## **AQUIND INTERCONNECTOR**

Applicant's Response to Deadline 5  
Submissions

Including Winchester City Council comments at  
Deadline 6 (25 January 2021)

**Table 2.6 - Winchester City Council**

TITLE: Application document reference 2.6  
Converter Station and Telecommunications  
Buildings Parameter Plans  
Combined Options  
Sheet 1 of 3

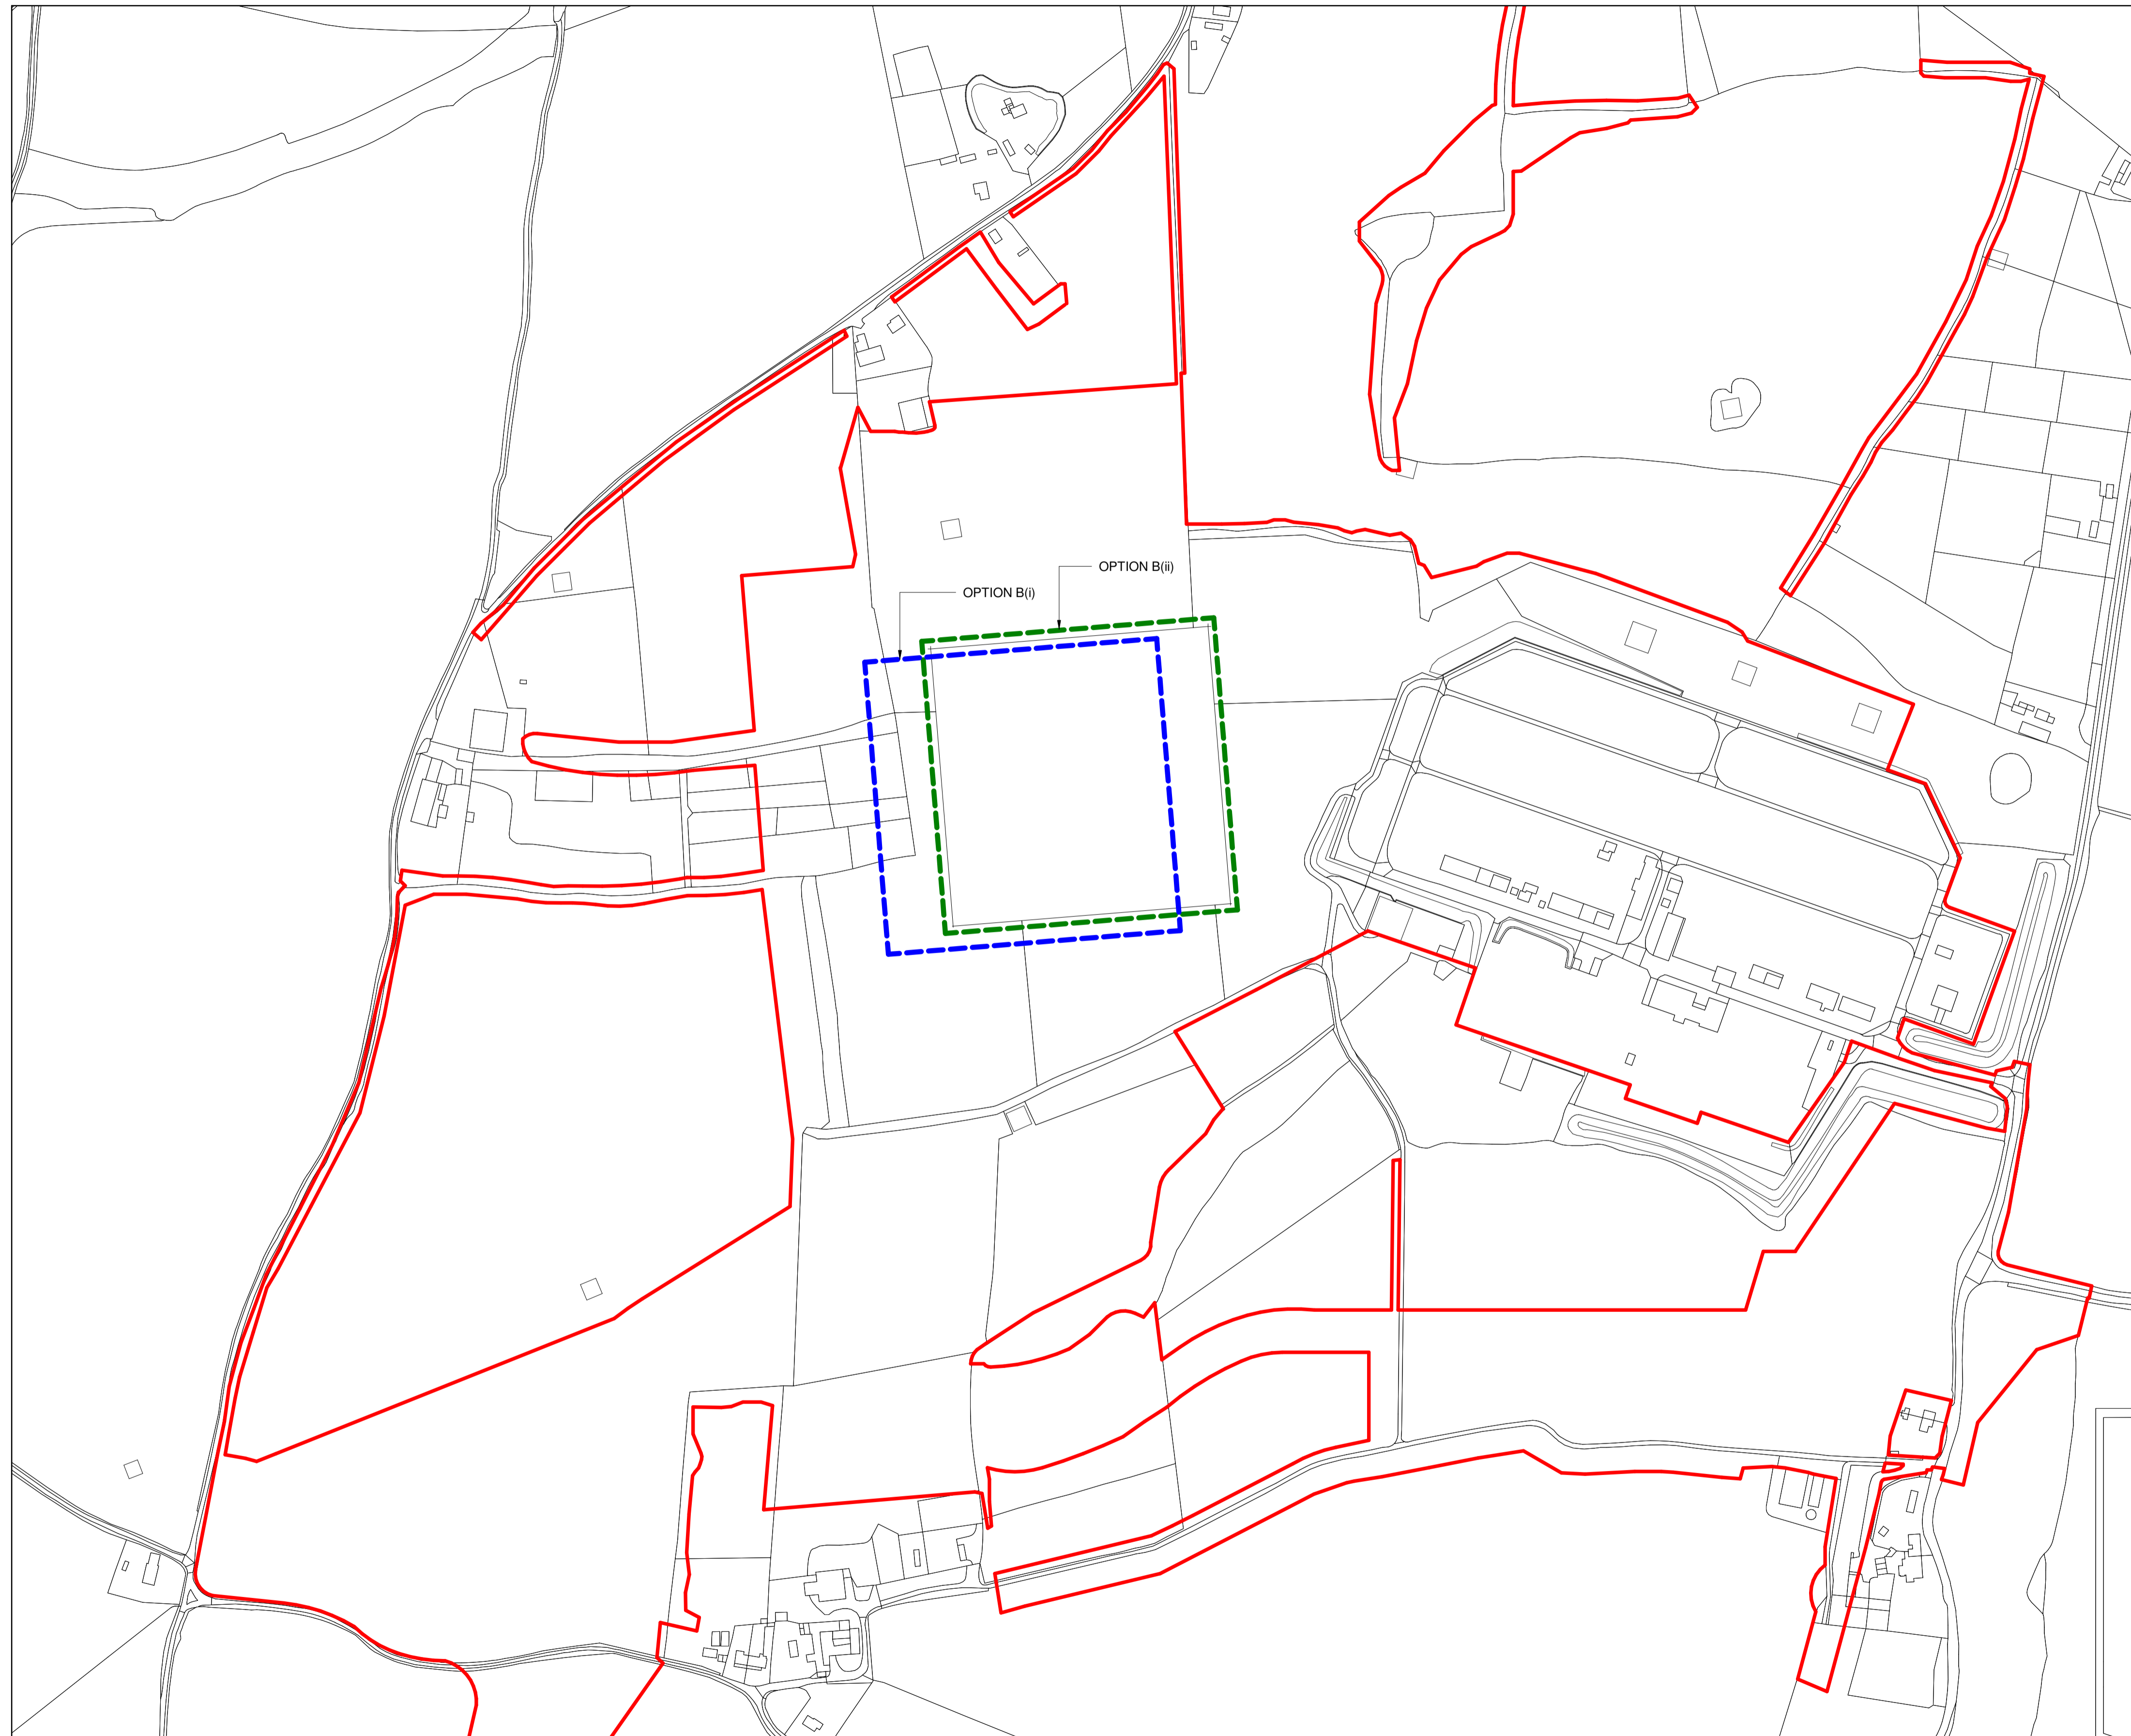
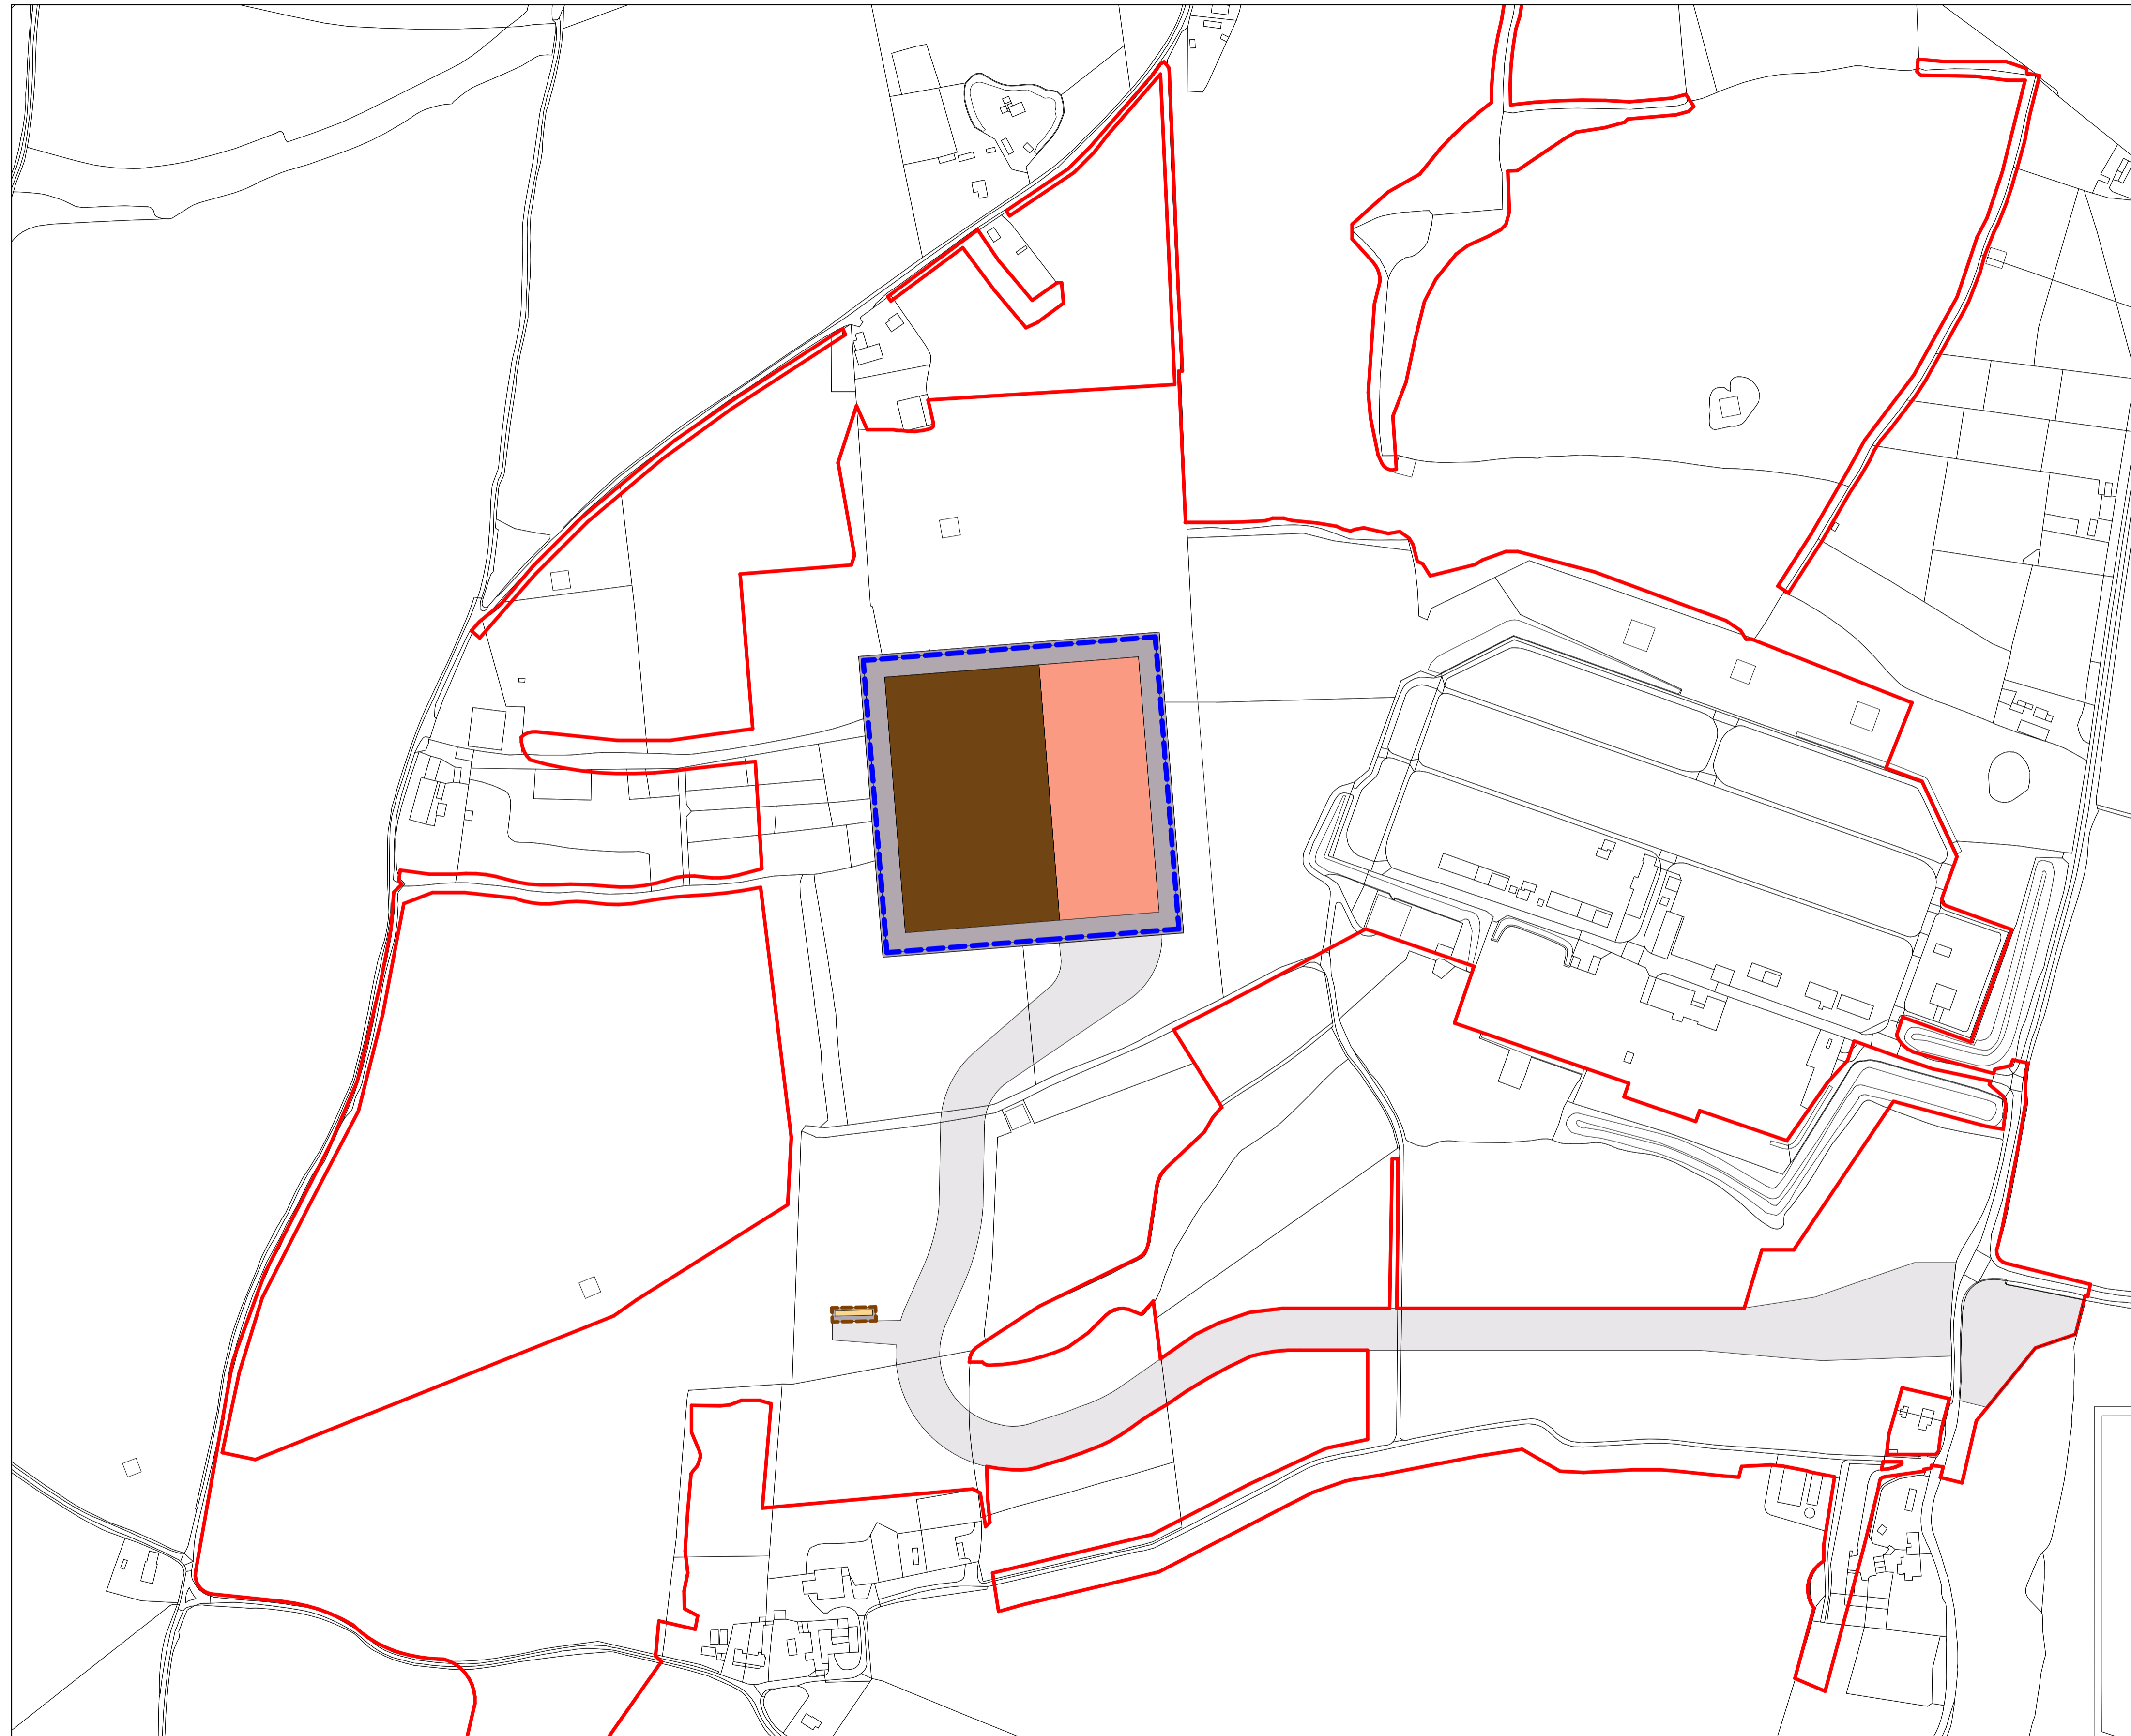
| Para No.   | Summary of Deadline 5 Submission   | Applicant's Response at Deadline 6  | Winchester City Council Comment  |
|--|--|---|--|
|  | <p>The Council notes the request to the applicant to clarify the situation regarding the Converter Station height. The Council wishes to take this opportunity to comment on that situation. It is understands that the height</p>   | <p>The Applicant seeks permission for buildings between 22m and 26m as stated in the draft DCO (REP5-008) and justified in the Design and Access Statement (REP1-031). These dimensions are based on advice which the Applicant has received from contractors</p>   | <p>See comments made to applicants D4 response.</p>  |

| Para No.                                  | Summary of Deadline 5 Submission  | Applicant's Response at Deadline 6   |   |
|---|---|--|---|
|   | <p>variation is to allow some flexibility in the design of the roof and its supporting structure. The final decision will rest with the contractor at the time the detailed design is finalised. The Council has sought clarification what weight will be given to minimising landscape impact in that decision.</p> <p>This is particularly pertinent if the lower building results in a higher capital outlay.</p>  | <p>experienced in constructing converter stations. As is explained in the Applicant's Transcript of Oral Submissions for Issue Specific Hearing 1 on Development Consent Order (REP5-058) in response to question 4.2 and in the Applicant's oral response in relation to the same, to ensure that no supplier is disadvantaged from offering their proposed technological solution the Applicant has sought to retain flexibility in respect of the height, and without this the Applicant would not be able to run a competitive tender process for the Converter Station taking into account the limited number of supplies of the bespoke equipment which comprises a converter station.</p> |   |
